WOODMOOR WATER AND SANITATION DISTRICT NO. 1

WELL NO. 22

EL PASO COUNTY, COLORADO SWMP, GRADING AND EROSION CONTROL PLAN

EPC STORMWATER REVIEW COMMENTS
IN ORANGE BOXES WITH BLACK TEXT

SHEET NO.
CE1.0

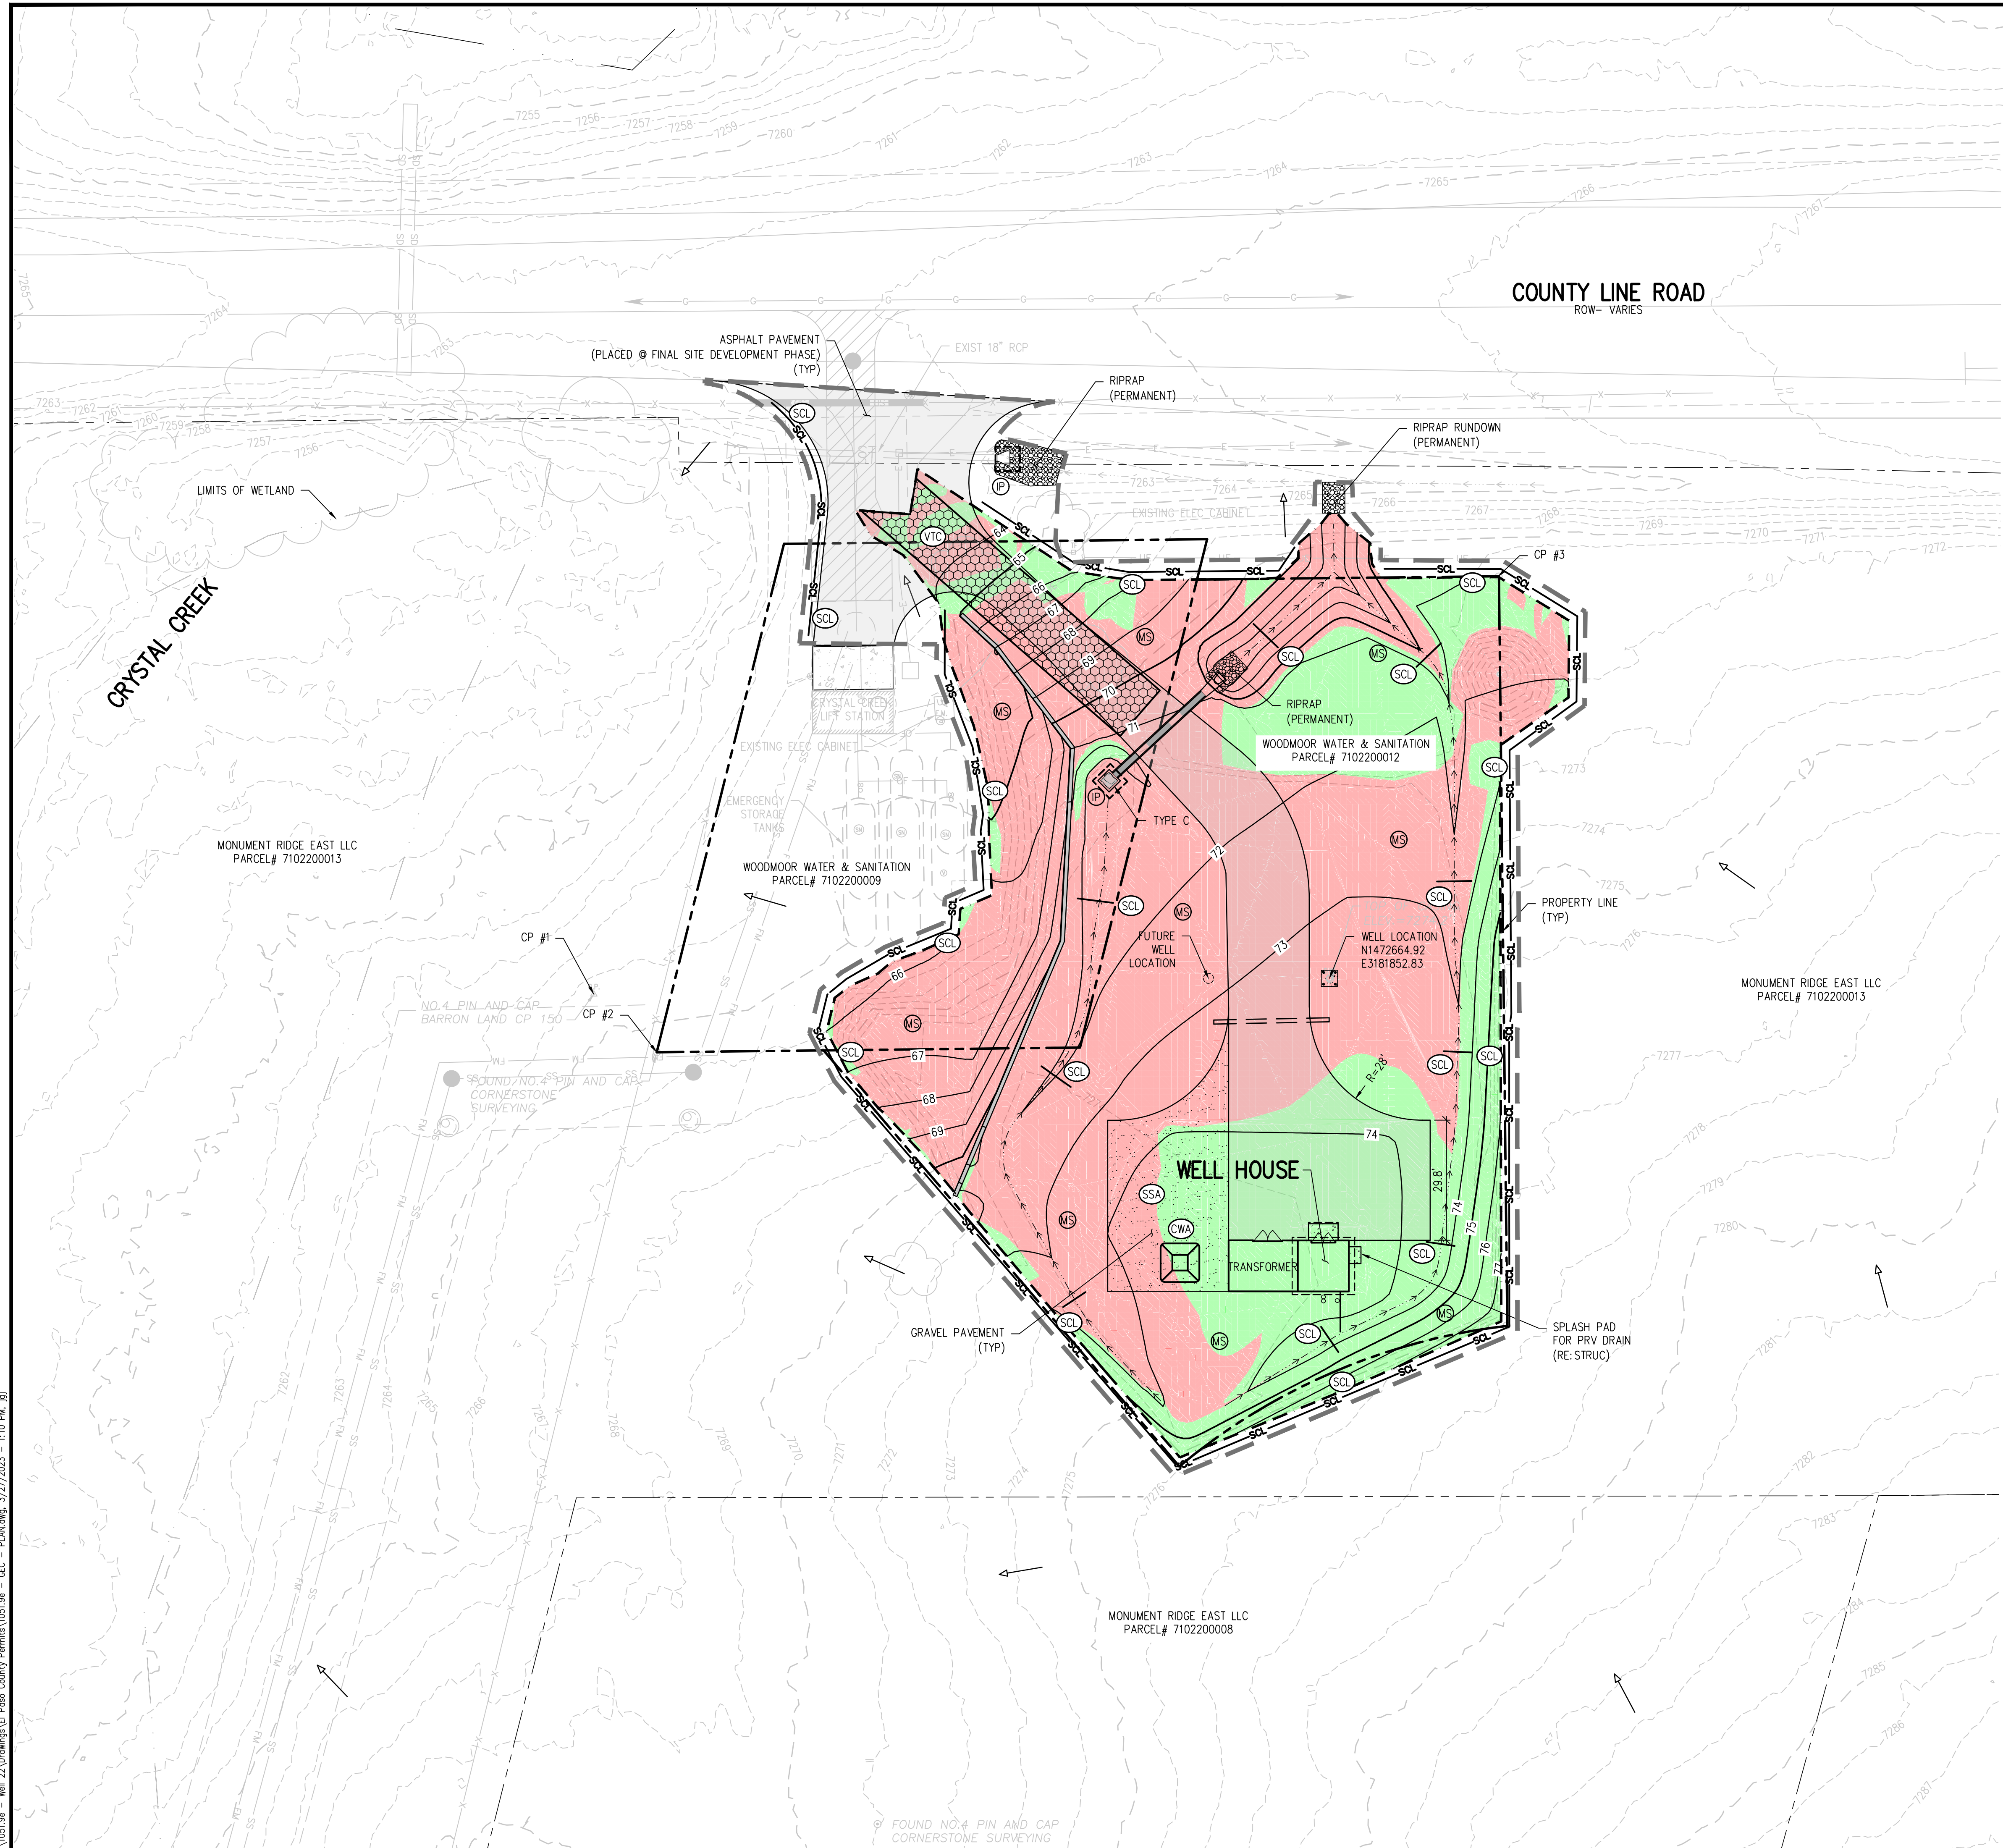
Label all structures as existing or proposed.

Verify if silt fence is proposed - if not remove from legend. I currently do not see silt fence on the GEC Plan.

Show MS limits.

Add developed drainage flow arrows on the plans.

Provide dimensions of riprap and size of riprap because detail says "see plans" for both.

Identify if the asphalt is existing or proposed. Clarify the driveway area. The GEC plan and Site Development Plan shows two different driveways.

Show construction easement for work outside of the Property Lines.

Identify the existing edge of pavement

Provide riprap dimensions because detail says "see plans"

Should this well be existing? Was this well built with filing CDR223? Verify.

Please identify surface material proposed at the drive aisle and throughout the site

Label proposed retaining wall and all proposed features.

The GEC plan for CDR223 Woodmoor WSD Well 22 shows very different grading. Because CDR223 has been constructed, the existing contours for this project should reflect the proposed contours of CDR223.

Show pattern in legend.

Consider need for inlet/outlet protection. If Utilized, add detail to this planset and update FAE form.

GEC Checklist item DD. Note: Regional Building Department permit required for all retaining walls greater than or equal to 4 ft in height.

Show the Property Line linework in the legend. Label.
